**EPA Advice on Environmental Impacts Statement
Air Liquide CO₂ Processing Plant – SSD-80824235**

I am writing in response to your request for advice from the NSW Environment Protection Authority (EPA) on the Environmental Impact Statement (EIS) for the proposed Air Liquide CO₂ Processing Plant at Bolong Road, Bomaderry.

Attachment A – NSW Environment Protection Authority (EPA) detailed comments on Environmental Impact Statement (EIS) for proposed Air Liquide CO2 Processing Plant (SSD-80824235)

Figure 3 Indicative Proposal site layout – processing site

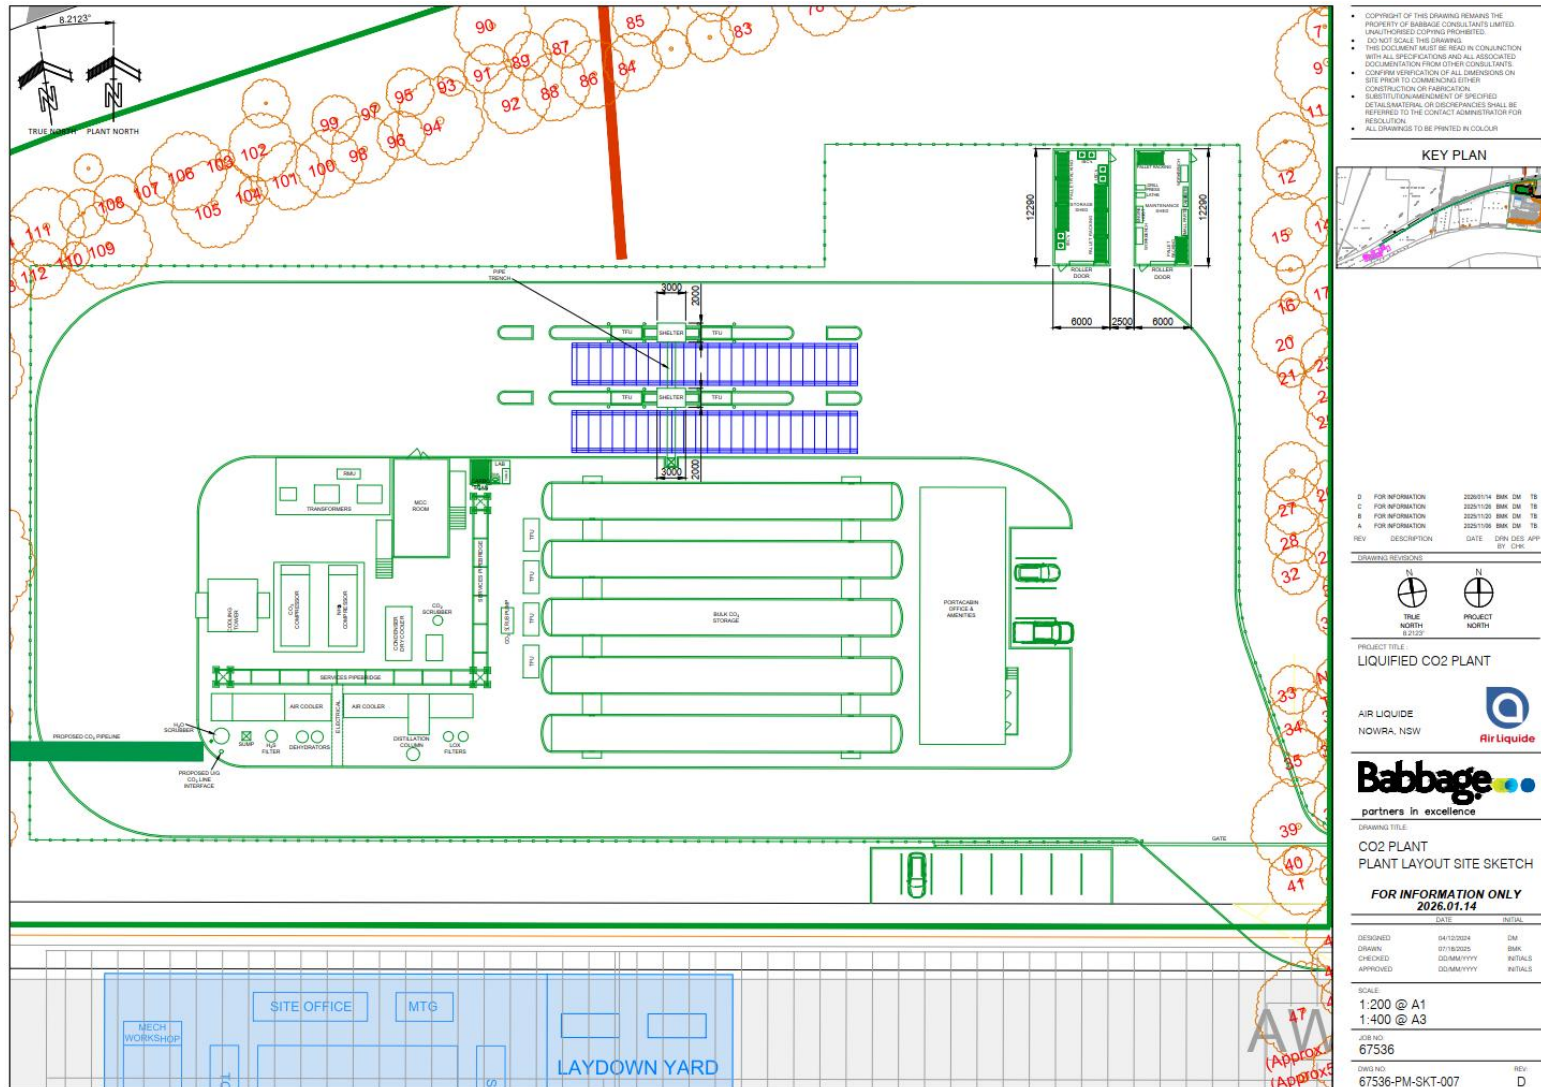
Table 2 of the AQIA provides an outline of the three emission points (130, 149, 224) assessed as part of the proposal. Section 5.2 of the AQIA states that upon conducting the initial modelling, elevated concentrations of certain pollutants were predicted at and beyond the site boundary (including sensitive receptor locations) due to low dispersion of emissions from point 224.

The AQIA stated that subsequent modelling combined the emissions from point 149 and point 224 to negate the effects of low volumetric flow and stack exit velocities from these emission points. However, it is not explicitly stated that the two emission points will be combined as part of the proposal, or if the combination of the sources was done as part of a modelling exercise only. The EPA advises that additional information should be included to confirm that point 224 and point 149 will be combined as part of the proposal.

Recommendation: The EPA recommends DPHI request the proposal provide additional information to confirm that point 224 and 149 will be combined as a single emission point.
